Our Ref: 20048269  
PINS Ref: EN010115  
Date: 12 November 2024  
Enquiries to: Mark Woodger

**Planning Act 2008****Application by Five Estuaries Offshore Wind Farm Limited for an order granting development consent for the Five Estuaries Offshore Wind Farm project.**

**Issue Specific Hearing 03****ISH 3 Effects of Terrestrial Traffic and Transportation**

DRAWING TITLE:
**2.18
 Temporary Speed Reduction Plan**

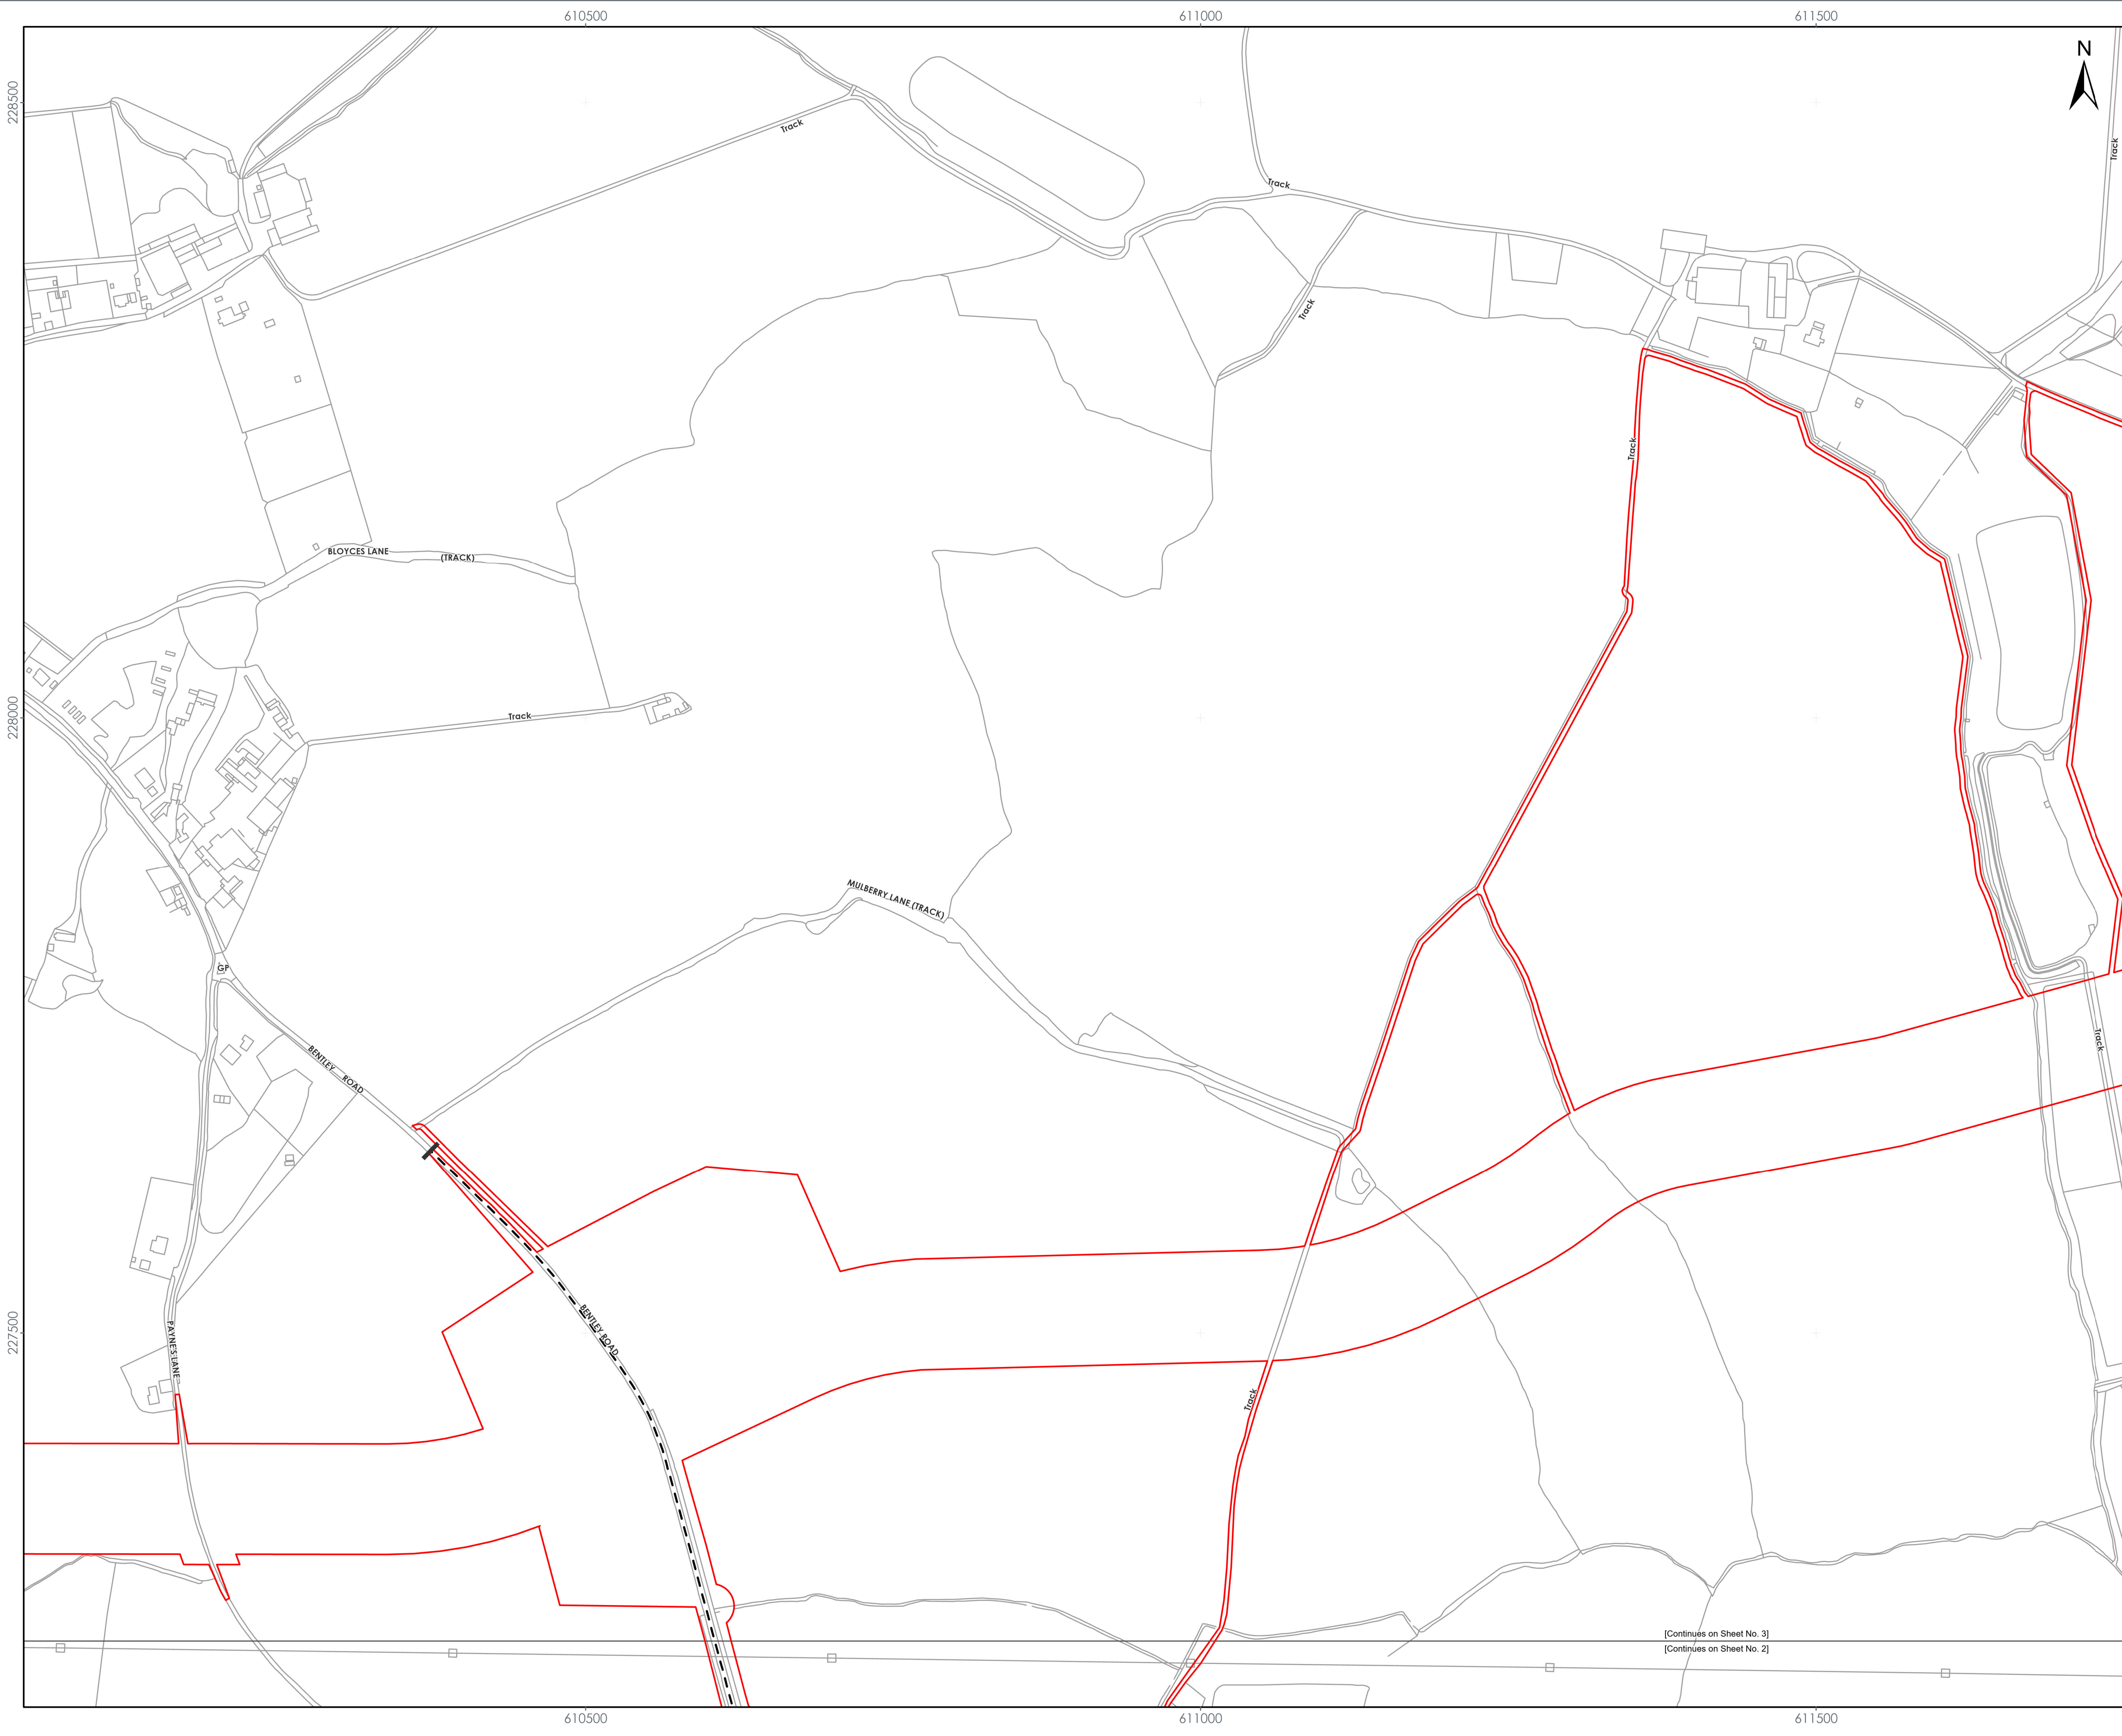
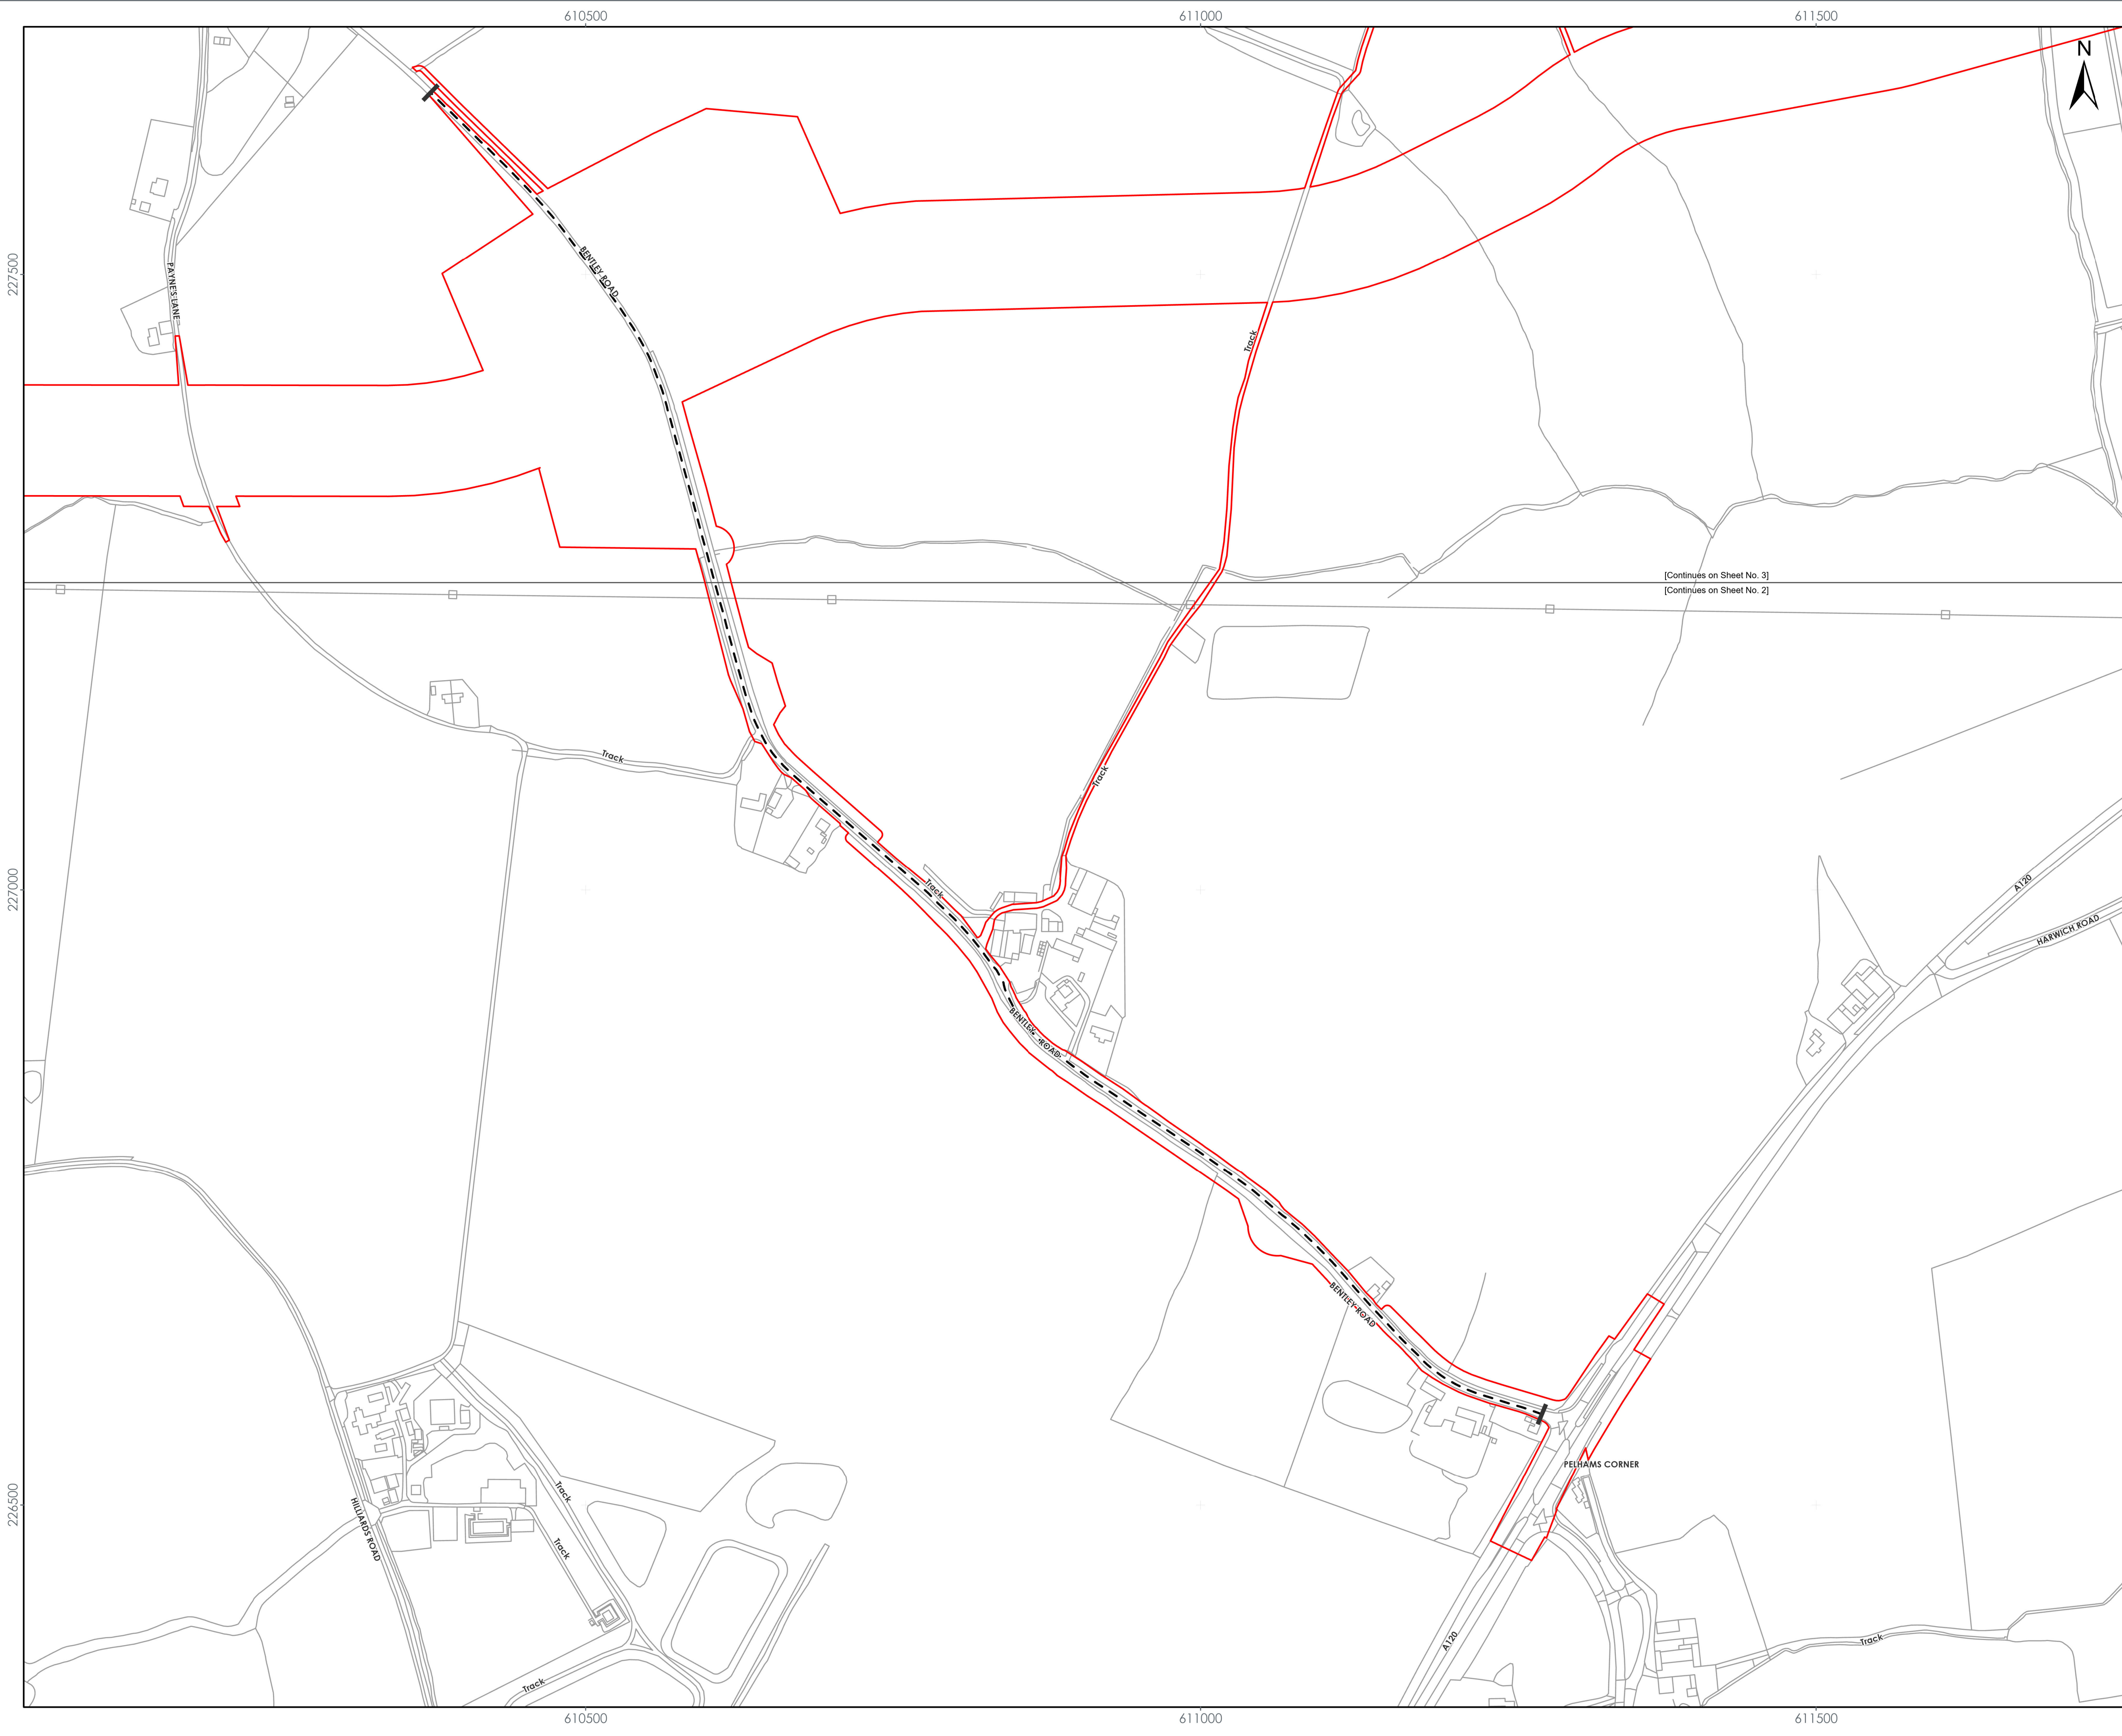
Change	Description
Inclusion of Paragraphs 8.7.10 and 8.7.18. Table 8.19.	<p>With regards to the speed limit change on the B1035 Thorpe Road (sheet no.3 of 7 on [AS-030], the Council are of the opinion that a 40mph speed limit is preferable over a 30mph speed limit at this location due to the local context, and that the speed limit should be extended to the south to include AC-4 (location shown on sheet no. 9 of 20 on [AS-023]. This would need to be reflected in an updated design of the access junction to include sufficient visibility for a 40mph speed limit.</p> <p>In addition to the comments above, it is considered that the speed limit change on Golden Lane (sheet no. 2 of 7 [AS-030]) be extended approximately a further 60m to the east to cover all the residential properties.</p>
